From: Michael Eastham <Michael.Eastham@arun.gov.uk>
Sent: 14 May 2021 13:32
To: Planning.Responses <Planning.Responses@arun.gov.uk>
Subject: FW: A/24/21/PL - Erection of a temporary sales cabin with 4 parking spaces and associated landscaping. CIL Zone 1 - This application is zero rated as temporary building.

Please upload onto Ocella the email below from **Angmering Parish Council** withdrawing its objection to planning application **A/24/21/PL**.

Subject: A/24/21/PL - Erection of a temporary sales cabin with 4 parking spaces and associated landscaping. CIL Zone 1 - This application is zero rated as temporary building.

| Org.No. | P1320.SALES.01 | Rev.  | B                  | PLANNING       |     |

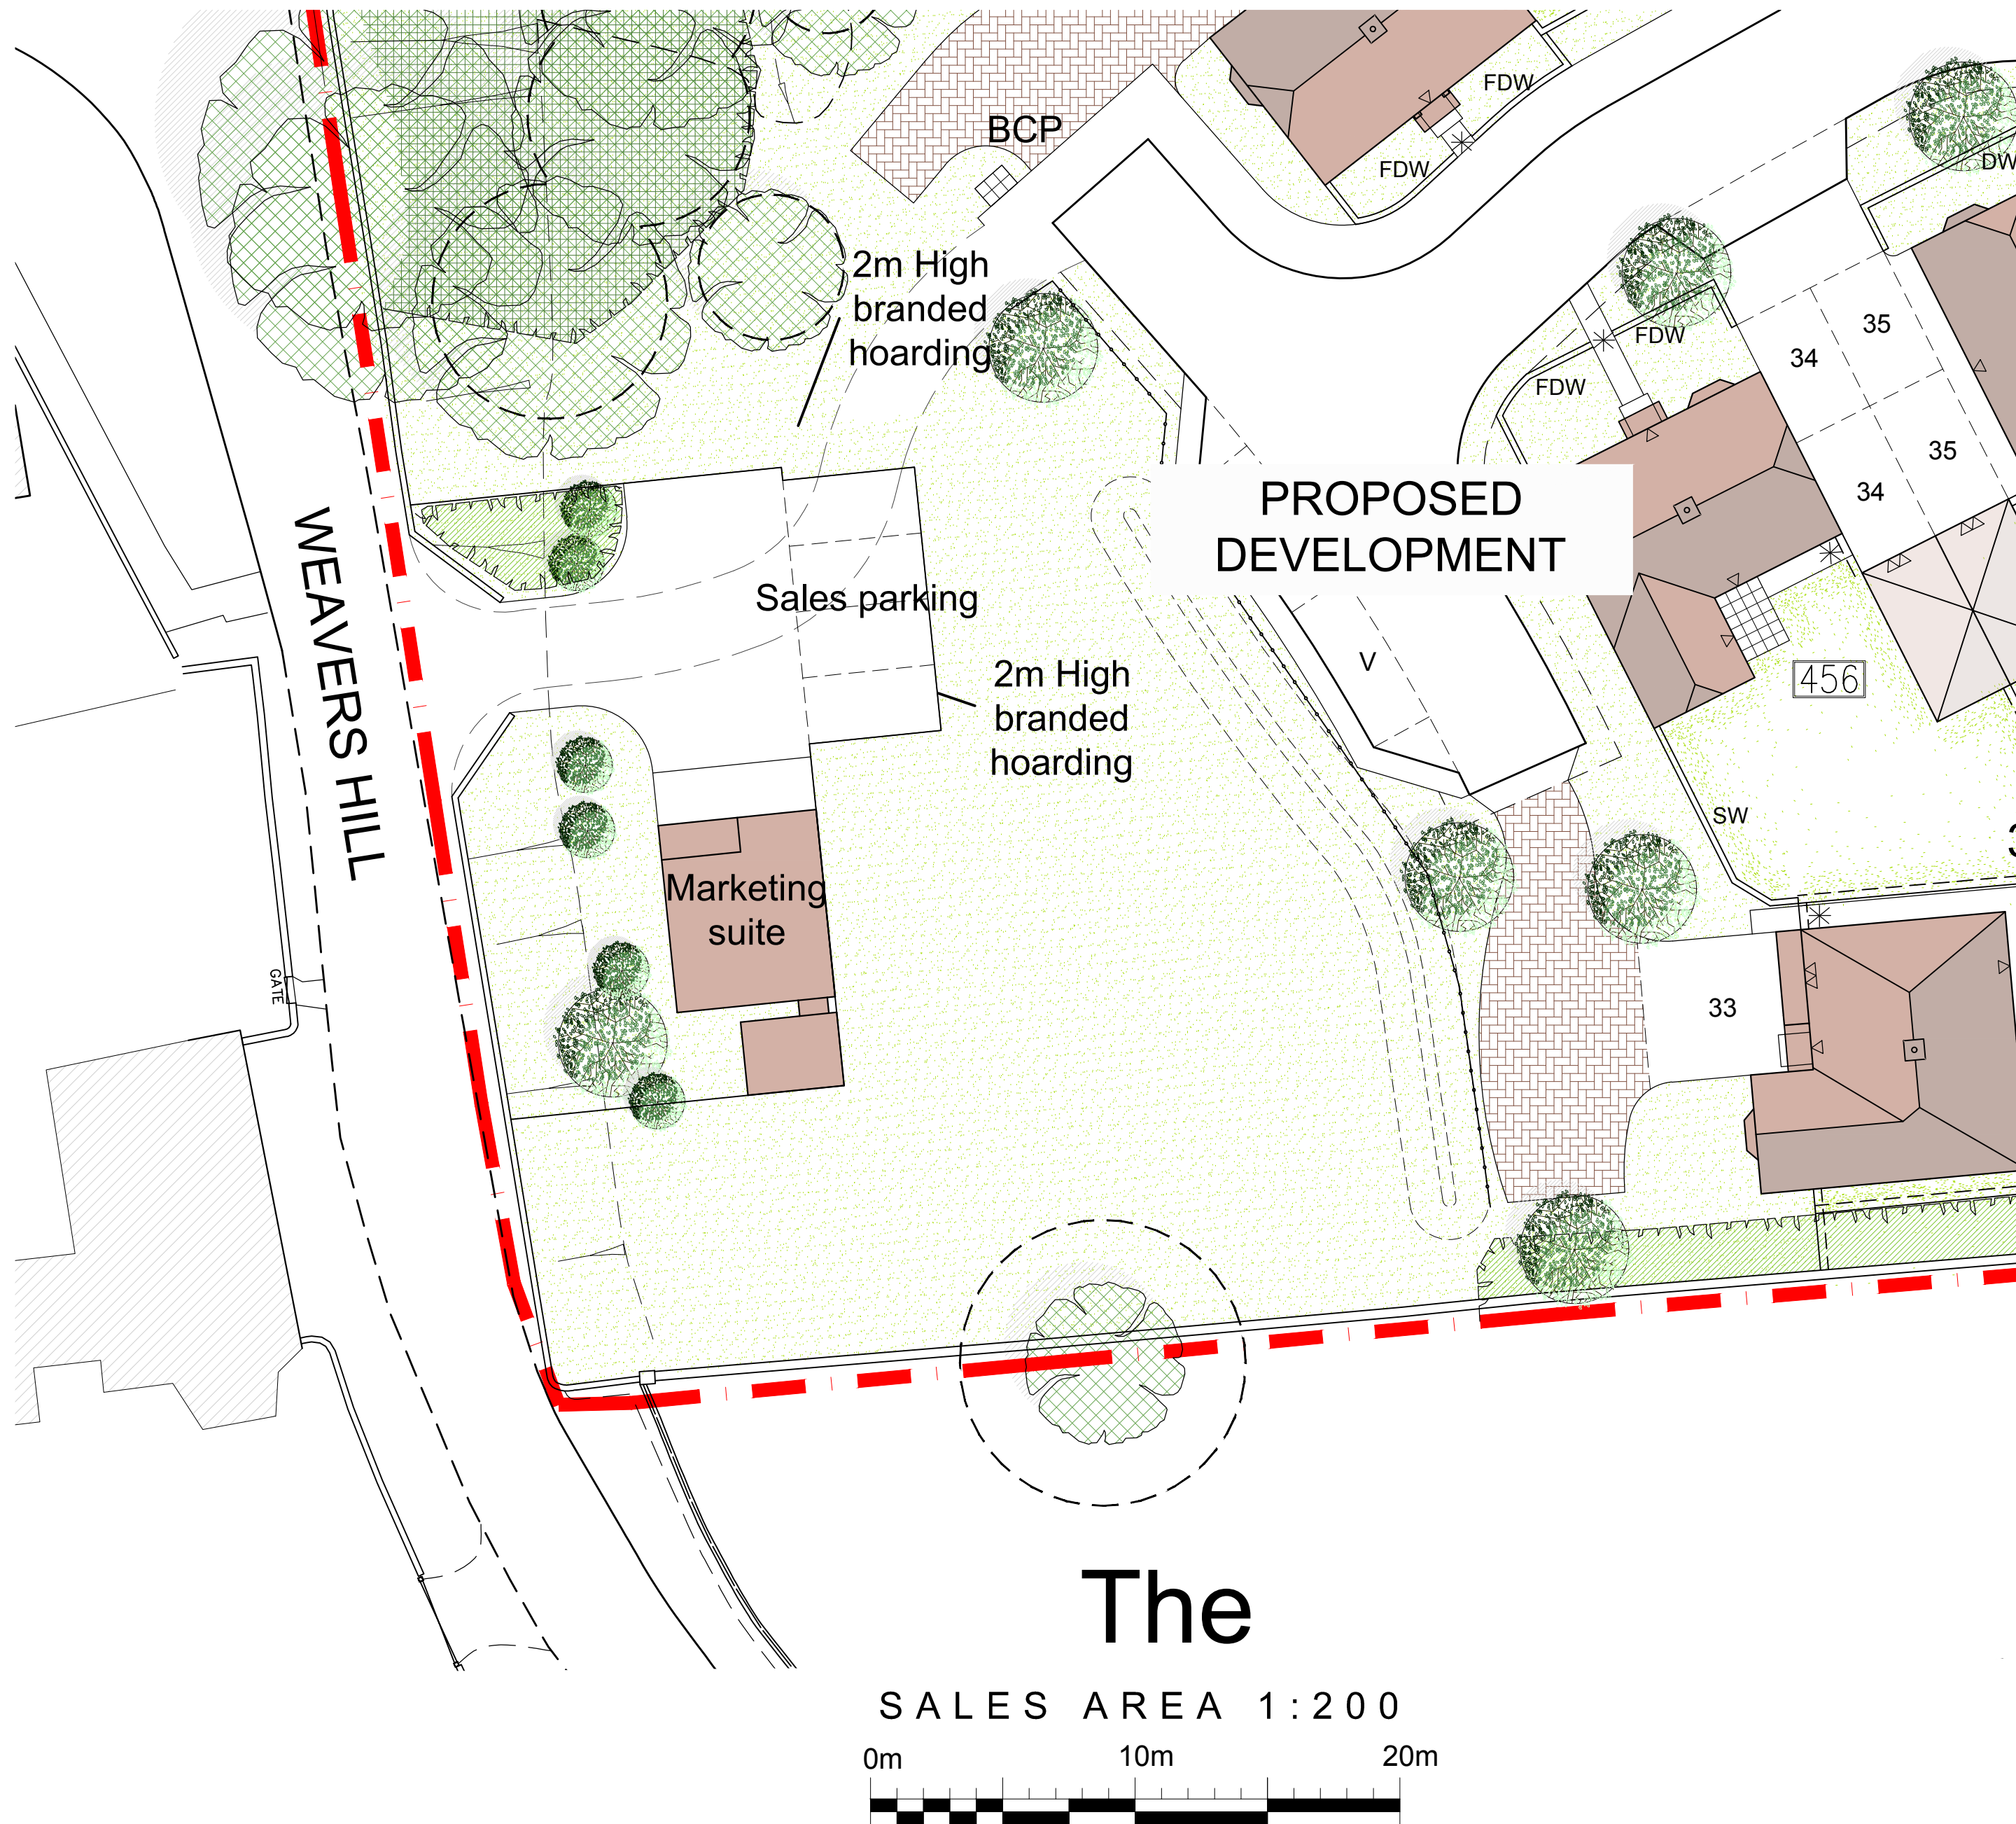
I can confirm that Angmering Parish Council will now remove their objection, on inclusion of the condition below

“Within 3 months of commencement, the length of flint wall which is proposed to be re-built, as indicated on Drawing No. P1320 SALES.01 Rev. B - Sales Area Layout shall be built to the existing wall”.

Although they are still not happy about the removal of a section of the flint wall, they accept that this was agreed during outline planning permission.
